## General Permit SWPPP Inspection

Site Name:	<u>CXCW ABQ 4th St. - Champion Carwash</u> <u>5307 4th St NW, Albuquerque, NM 87107</u>	Inspector:	Diana Monroe
Permit #:		Inspection Frequency:	Bi-weekly -
Date of Visit:	Sep 15, 2023, 1:29:31 PM	Last Rain Event Thursday, September 14, 2023, 0.0"	Last Precipitation Wednesday, September 13, 2023, 0.42" 48h Forecast 21% Chance of Rain

C-6.0

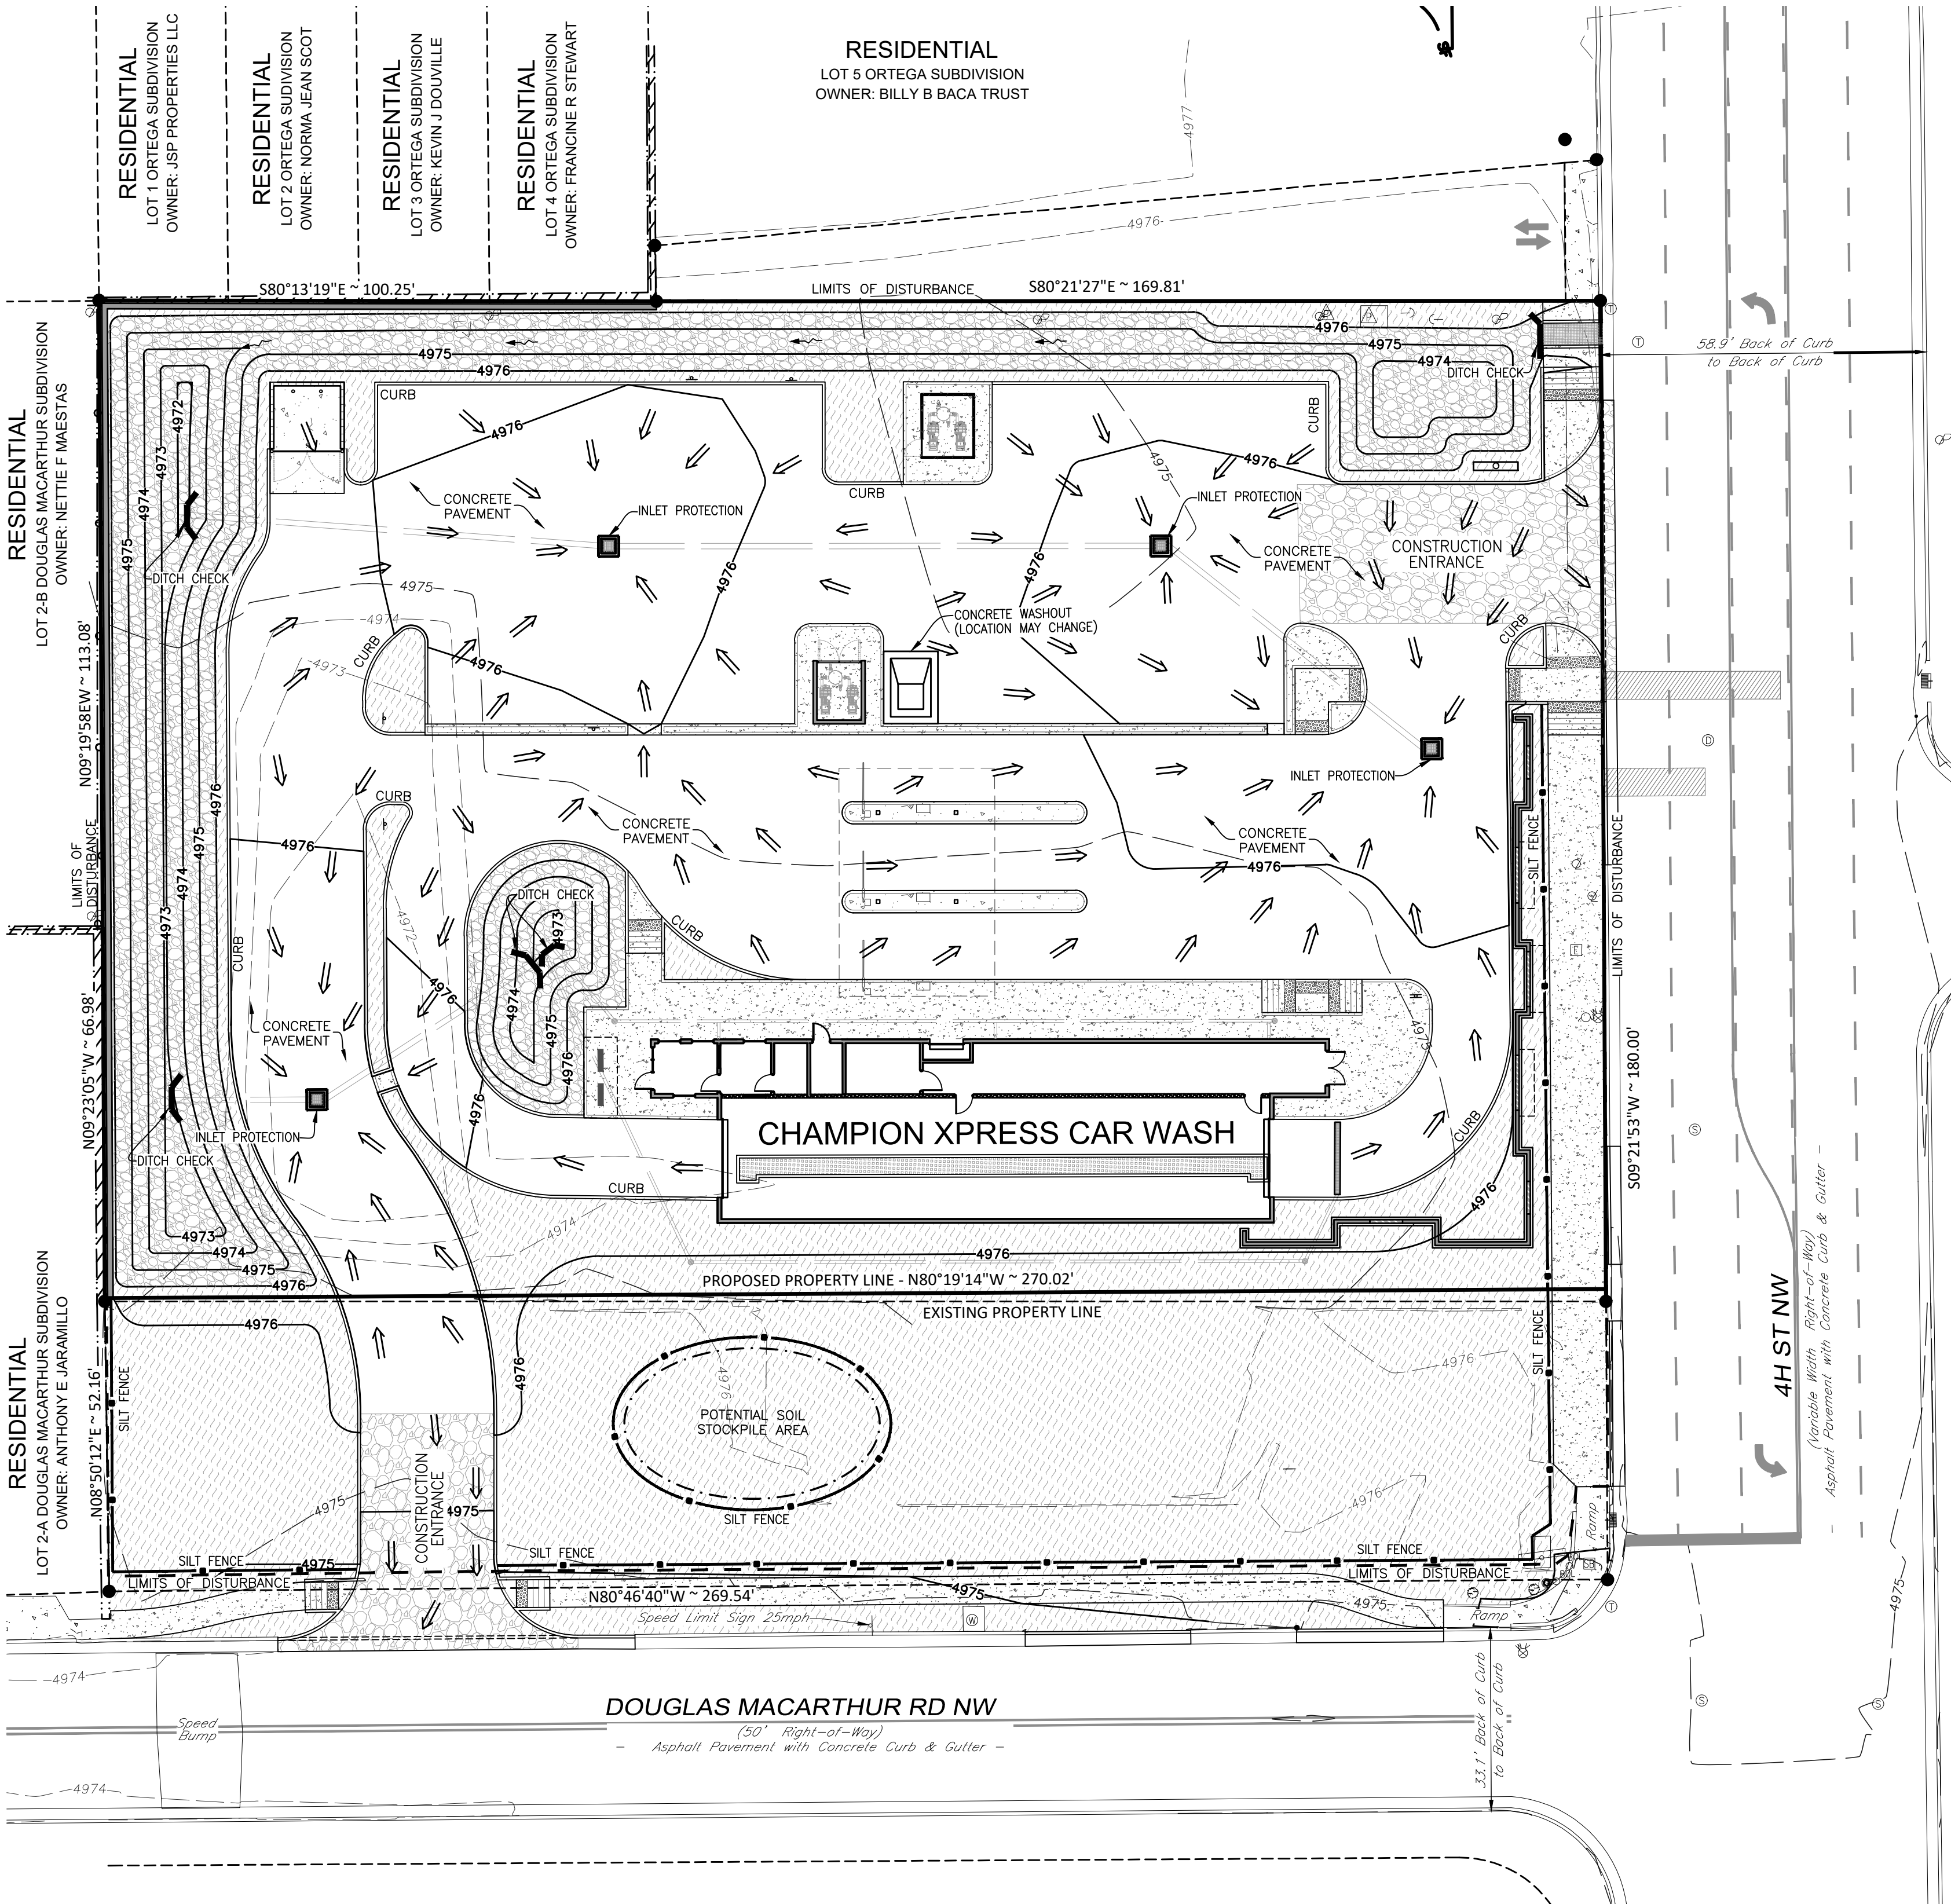
Silt fence on 4th street side needs to be replaced/repared, Silt fence to the west of construction entrance needs replaced or repair. Waddles need to be properly installed along fencing on 4th street.

Construction entrance has been removed and no concrete has been pour like superintendent said was getting done 2 weeks ago, recommend installing waddles against opening on outside of gate to prevent sediment from entering the street.

Construction Entrance		Diana Monroe	September 15, 2023	Immediate	South side of property at construction entrance	Track out pad (rock) Has been removed and concrete has not been poured like superintendent said was getting done. would recommend installing waddles against gate on the outside of the gate opening to prevent sediment from entering the street	Open			 <a href="#">Photo 1</a>
Concrete washout	Diana Monroe	Diana Monroe	August 18, 2023	Immediate	Near construction entrance	Concrete washout does not have a liner in it. Concrete washout needs to be cleaned and area around	Closed September 15, 2023	Diana Monroe	Lined concrete washout was present at time of inspection	 <a href="#">Photo 1</a>  <a href="#">Photo 2</a>  <a href="#">Photo 3</a>
